Bruce Davis
45 Quebec Street, Portland Maine 04201

Planning Board
Portland, Maine

September 10, 2016

I am an owner-occupant at my property at 45 Quebec Street, an abutter to the proposed multi-family project for 30 Merrill Street, and I attended the public meeting held by architect Evan Carroll and developer Michael Boissoneau on August 15th at East End School. As a neighbor I consider myself a significant stake-holder in how new development affects the fabric of the much-valued community that currently exists in the East End. I am in no way opposed to new development or appropriate changes to the existing fabric of the neighborhood. As a stake-holder I am sensitive to architectural interventions' potential to add value to the context of the existing neighborhood, or conversely to potentially work against making the neighborhood even better.

1 MERRILL STREET NORTH

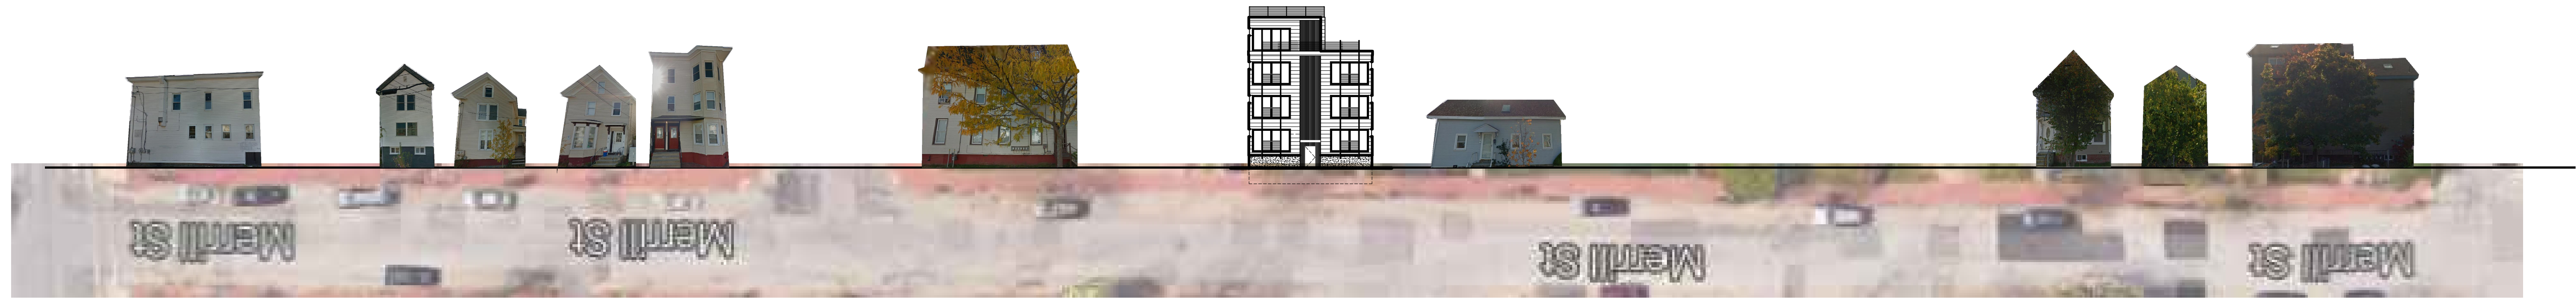
My personal concerns about the project are entirely about what kind of neighbor this property will be on Merrill Street and beyond. I don't have any issues with the scope or scale of the property or creating greater density at this site - those are broader Portland Planning goals that I support. I am fine with the building's massing. The almost complete lack of contextual elements as presented in the preliminary AND revised renderings are my biggest concern: the vertical balcony elements that Mr Carroll states in his Design Standards Assessment as "stacked and articulated to pay homage to the traditional bay window" entirely unconvincing from reviewing his renderings. Similarly, the standing-seam cladding is a material alien to the streetscape, and the scale of the cladding elements is out-of-scale with local materials, so that his argument that the horizontality of the cladding makes it appear contextual is unconvincing as well.

In order to actually be contextual, I believe the siding should be actual clapboard or shingle elements - abstract "homages" that are not evident to a room full of neighbors viewing the renderings are not meeting criteria for being contextual. Similarly, the fenestration is also entirely out of synch with residential architecture on the Hill, as the renderings made evident. Abstract language attempting to substantiate contextualism needs to be evident to real people who live on the street and the city.

This project seems to fit the cliché of a "box that dropped out of the sky" – the opposite of contextual. Mr Carroll made a strong argument for new construction in Portland to be forward-looking, with which I agree. I would never say additions to the neighborhood need to look like they were always there, however Mr Boissoneau stated in the meeting that context is subjective, to which I replied it can also be objectively assessed, which is what I am advocating for here. The proposed project does not appear to be trying to be contextual. There are numerous examples on the Hill of new construction that is both forward-looking and contextual. To suggest that this project is one of them would be disingenuous. Mr Boissoneau stated that "We want the neighborhood to be accepting of it" (the design). I question why the essentially same design was resubmitted if this is the intent.
